From: Amanda Scholes on behalf of Planning.Responses
Sent: 23 May 2018 10:41
To: Planning Scanning
Subject: FW: LY/3/18/HH and LY/4/18/L - Replacement Gates, Lyminster House, Church Lane

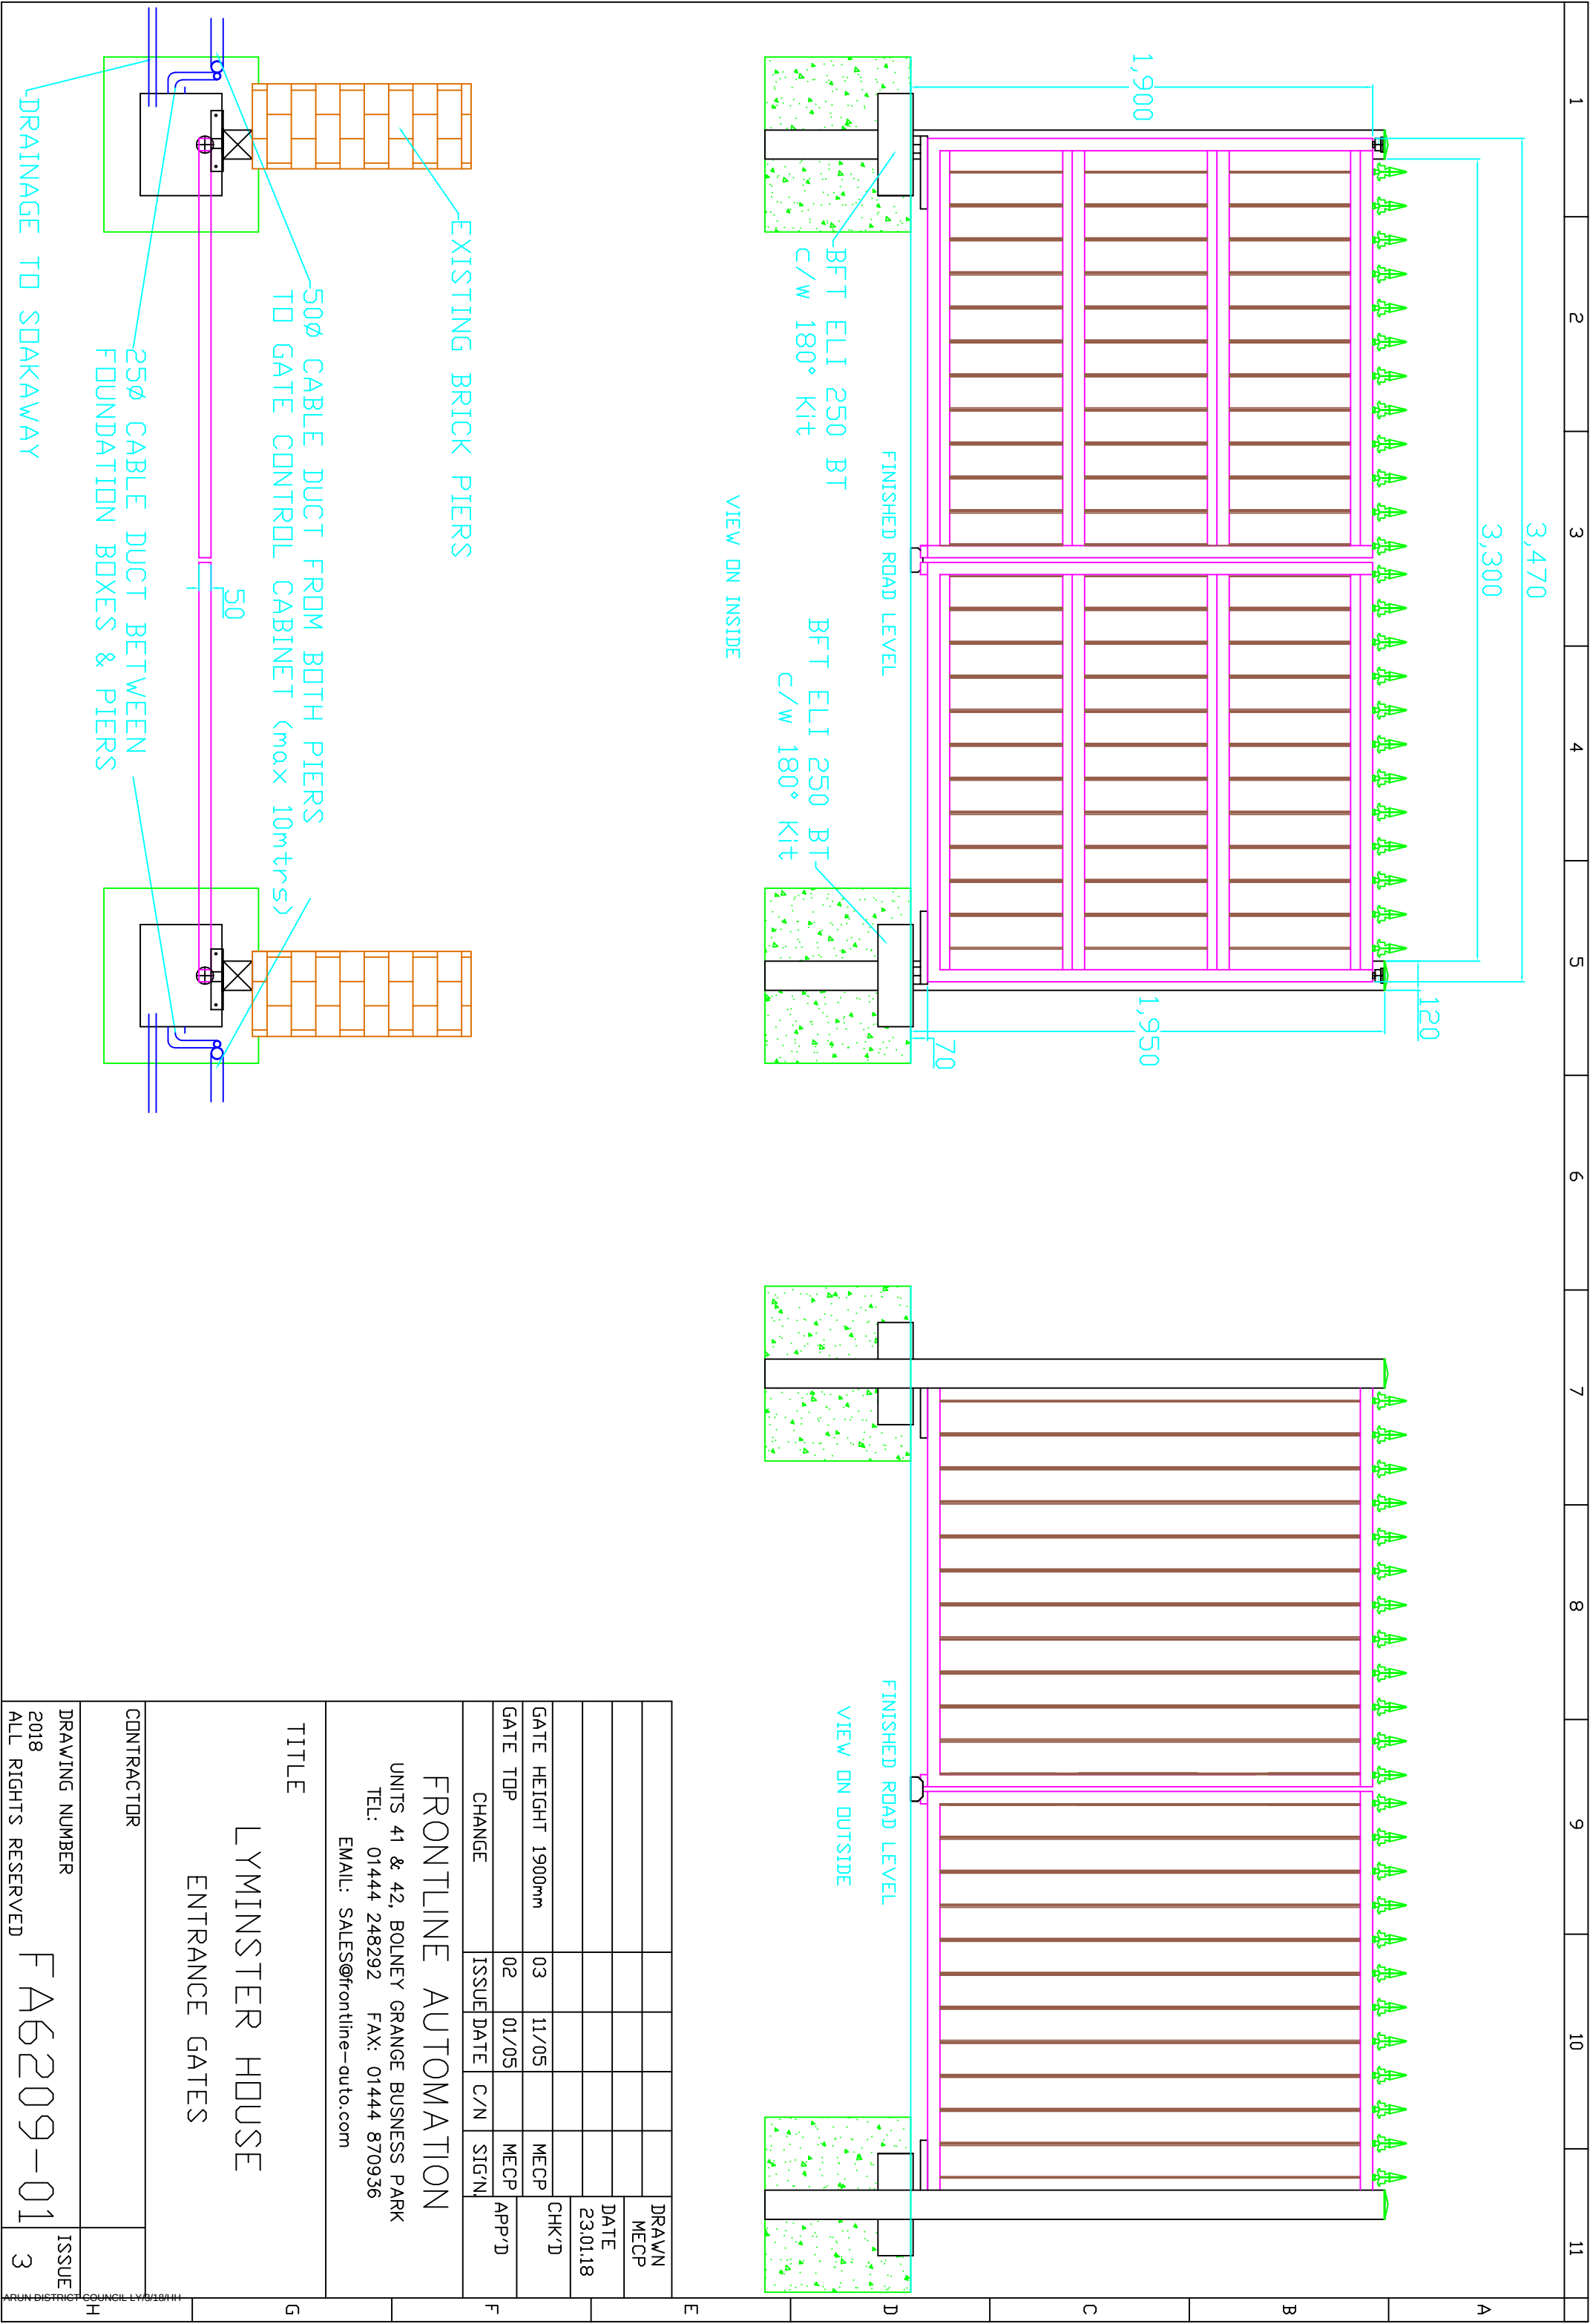
“ While there is no objection in principle to the replacement of the gates, including an automation system, it is recommended that the profile of the replacement gate be either: horizontal to top edge, giving a more traditional profile OR downsweeping OR be metal gates. There is a concern that the new steel posts to support the proposed gates would be visually intrusive, and it is preferable that these be set to brick piers (concealing electrical works/mechanisms etc). Other than this, a manual gate could be fitted. I would currently recommend the proposed gates be refused.”

I would therefore appreciate that consideration is given to modifying the design of the gates accordingly. To allow time for receipt of amended details I would be grateful to your agreement to an extension of time on the applications until 24-05-2018, by return.

1. Pair of Close Boarded Wooden Vehicle Gates with Steel Frame and Sapele infill to Suit Opening of 3220mm wide by 1900mm high
2. Frame and Top Spikes -Black RAL9005
3. Infill -Painted White Gloss
4. Pair of Steel Posts c/w Top Hinges. Colour RAL9005 Black

As discussed please find attached a revised drawing for the gates. You will note:

- Steel posts to the rear of the existing brick piers (as per original drawing). Please also note that at additional cost the gate mechanisms will be located underground further reducing any visual impairment in keeping with the character of the property.
- Revised horizontal design of the gates themselves as per our discussion
